Advice regarding Amendments to Environmental Impact Statement – State Significant Development – Kariong Sand and Soil Supplies Facility – (SSD – 8660) – Central Coast LGA

HNSW has reviewed the new information, including the *Response to Submissions Report Kariong Sand and Soil Supplies, Sand, Soil and Building Materials Recycling Facility - SSD 8660*, dated 5 January 2021, prepared by Jackson Environment and Planning Pty Ltd and notes that no new information has been supplied by the applicant in relation to Aboriginal cultural heritage.

Dr Samantha Higgs
Senior Team Leader
Aboriginal Cultural Heritage Regulation - North
Heritage NSW

Date: 21 January 2021

Figure 8 Survey results

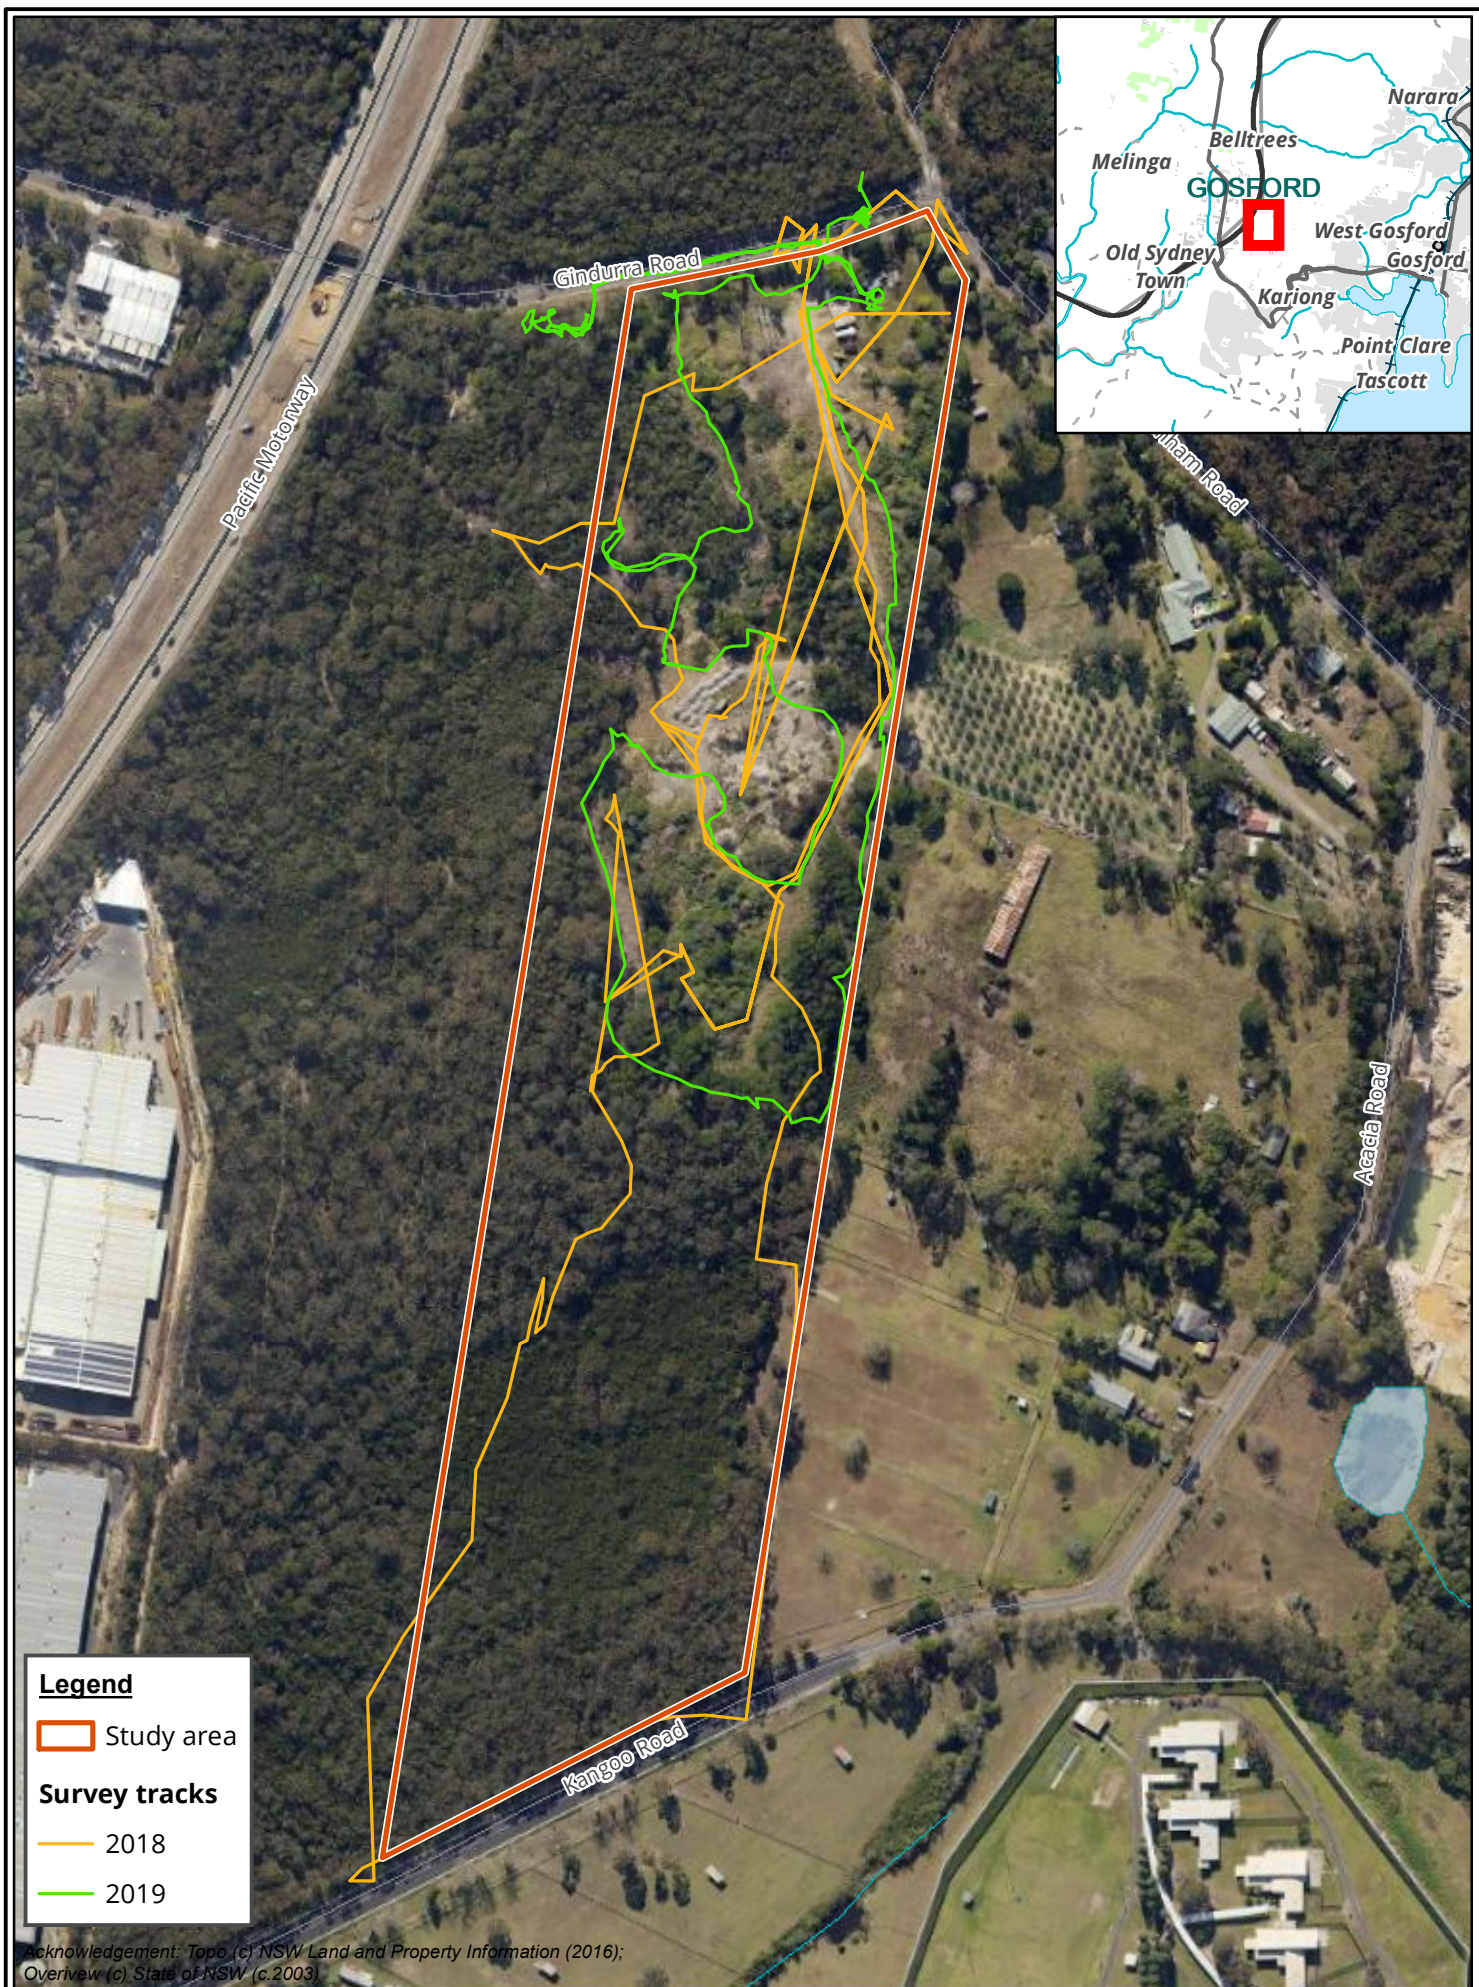
2. Re-survey of the southern half of the project area should occur following surface removal of vegetation

HNSW has reviewed the results of the field survey undertaken with the RAPs and noted the results were inconclusive as the effective coverage in the southern half of the project area was 0% due to heavy vegetation. The AR argues that the low-lying ground in the southern half of the project area precludes Aboriginal occupation in this part of the project area (AR 2020:33) and the likelihood of Aboriginal objects in this area is low. The extensive archaeological record and the significant Aboriginal cultural values of the immediate area and broader Somersby locality do not support this assumption. HNSW is of the view that the identification of potential Aboriginal sites being present in this part of the project area was prevented due to a lack of visibility.

HNSW recommends that survey of the southern half of the project area should occur following surface removal of vegetation. Procedures for vegetation removal must be prepared and included in the ACHMP.
